***Somersby Drill Mud and Oily Water Recycling Facility (SSD-62863964) (Central Coast)134  
Somersby Falls Rd SOMERSBY) – Council Submission***

I refer to your email sent on 25 February 2025 where you requested Council to provide a submission response regarding SSD-62863964 within the exhibition period being 25 February 2025 – 24 March 2025. The following commentary comprise Council's formal submission response.

Figure 3 | Proposed Site Layout

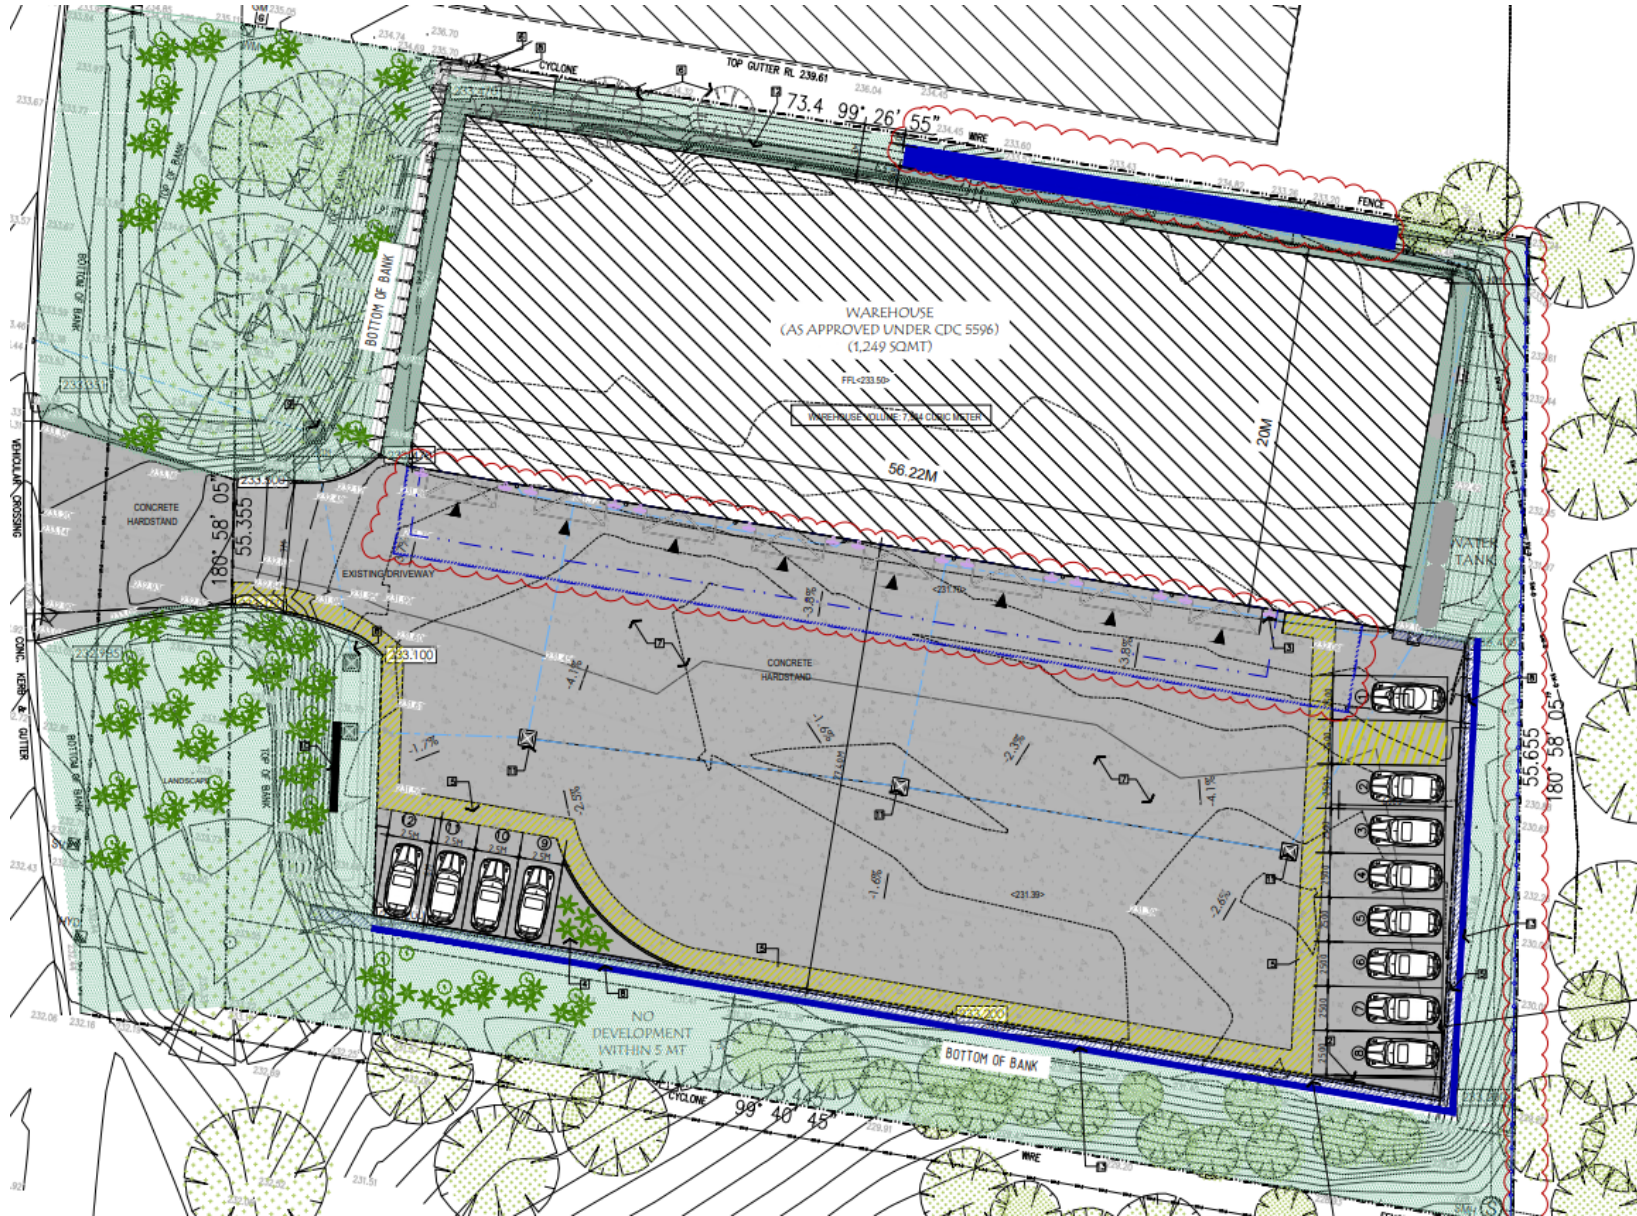
Under Part 3, Division 2, Clause 36 of the *Protection of the Environment Operations (Waste) Regulation 2014* an occupier of a scheduled waste facility who is required to pay contributions under Section 88 of the *Protection of the Environment Operations Act 1997* (that is a waste facility that are required to be licenced under the Act) must install a weighbridge at the waste facility. The proposed resource recovery facility falls into this category and as such a weighbridge must be installed at the facility. A weighbridge is not provided on plans. Further information is requested.

1. Provide detailed site plans of the weighbridge required by the SEARS and in accordance with Part 3, Division 2, Clause 36 of the *Protection of the Environment Operations (Waste) Regulation 2014*.

Figure 4 | Proposed Ground Floor Plan

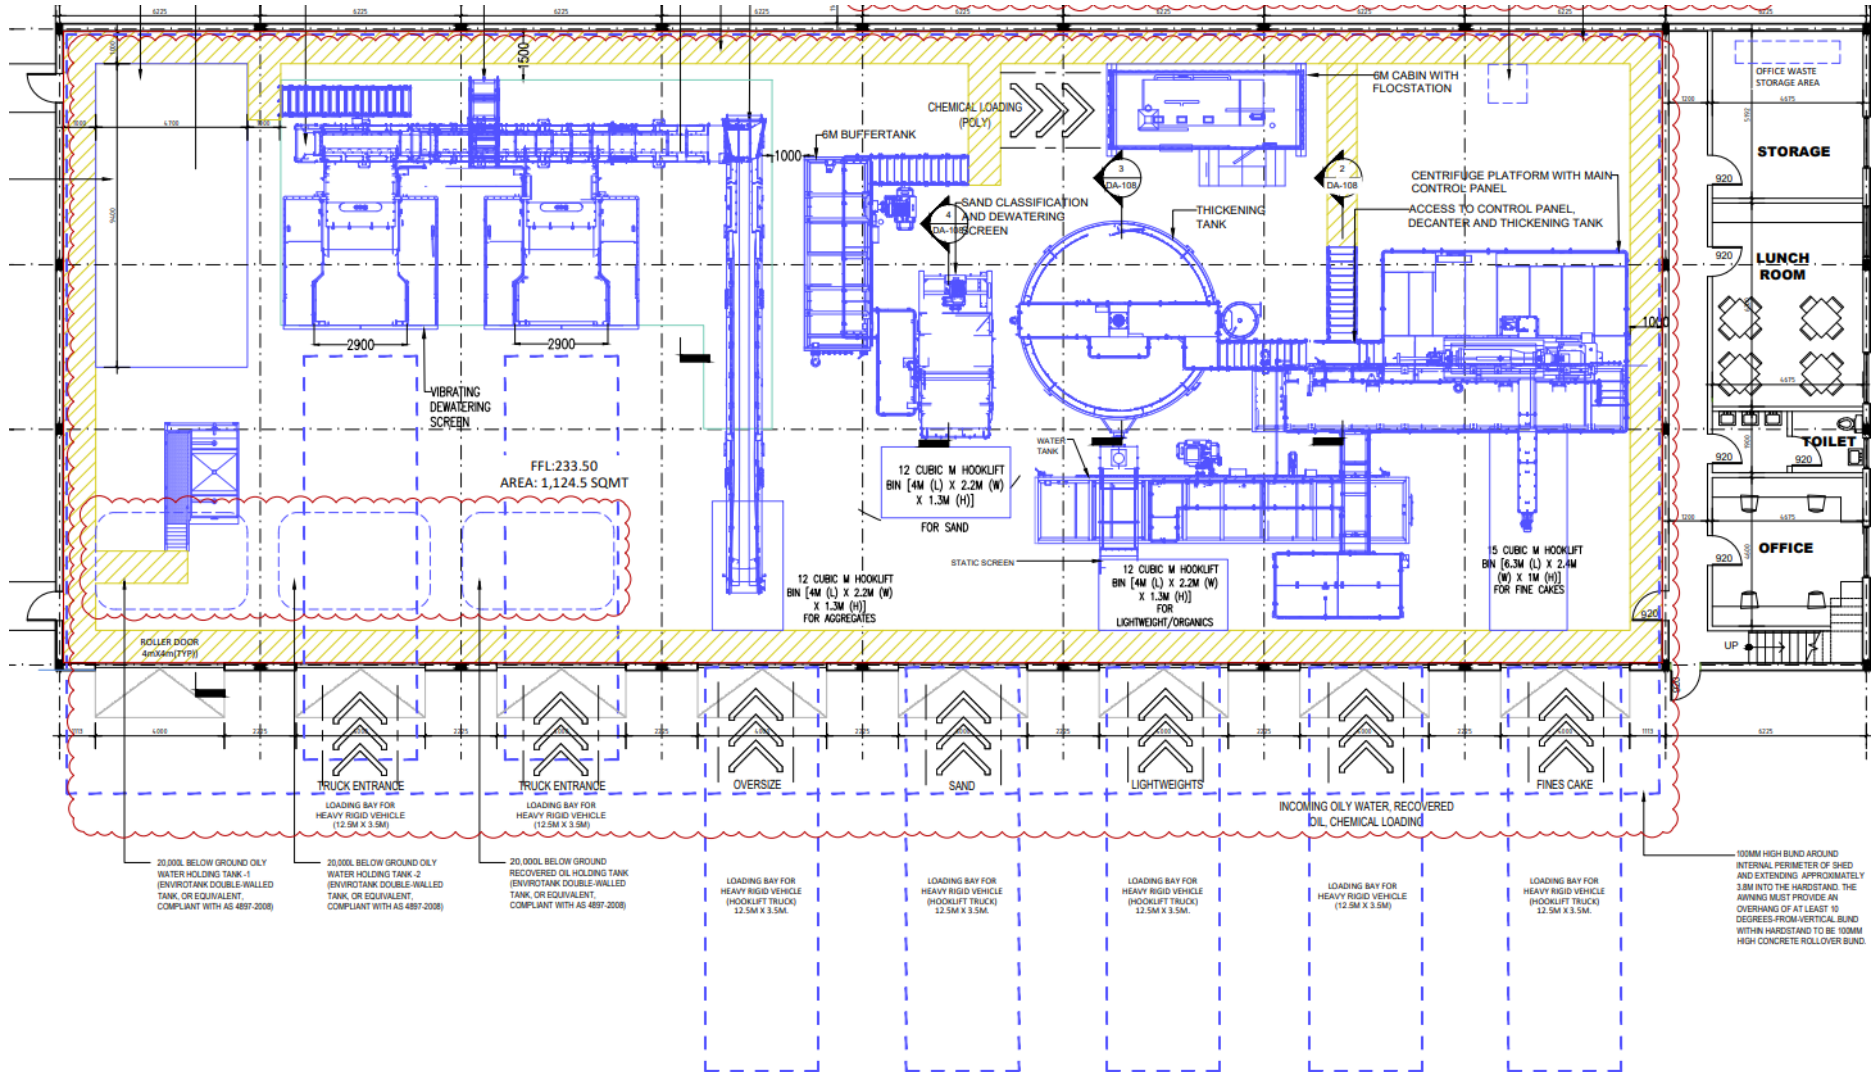
- Verify that the works constructed within the hardstand areas under CC 596/01 have provided the required above ground on-site detention volumes, and
- Confirm that the proposed bunding under the proposed awnings on the southern side of the existing shed building will not impact on the on-site above ground detention volumes required under CC 5596/01.
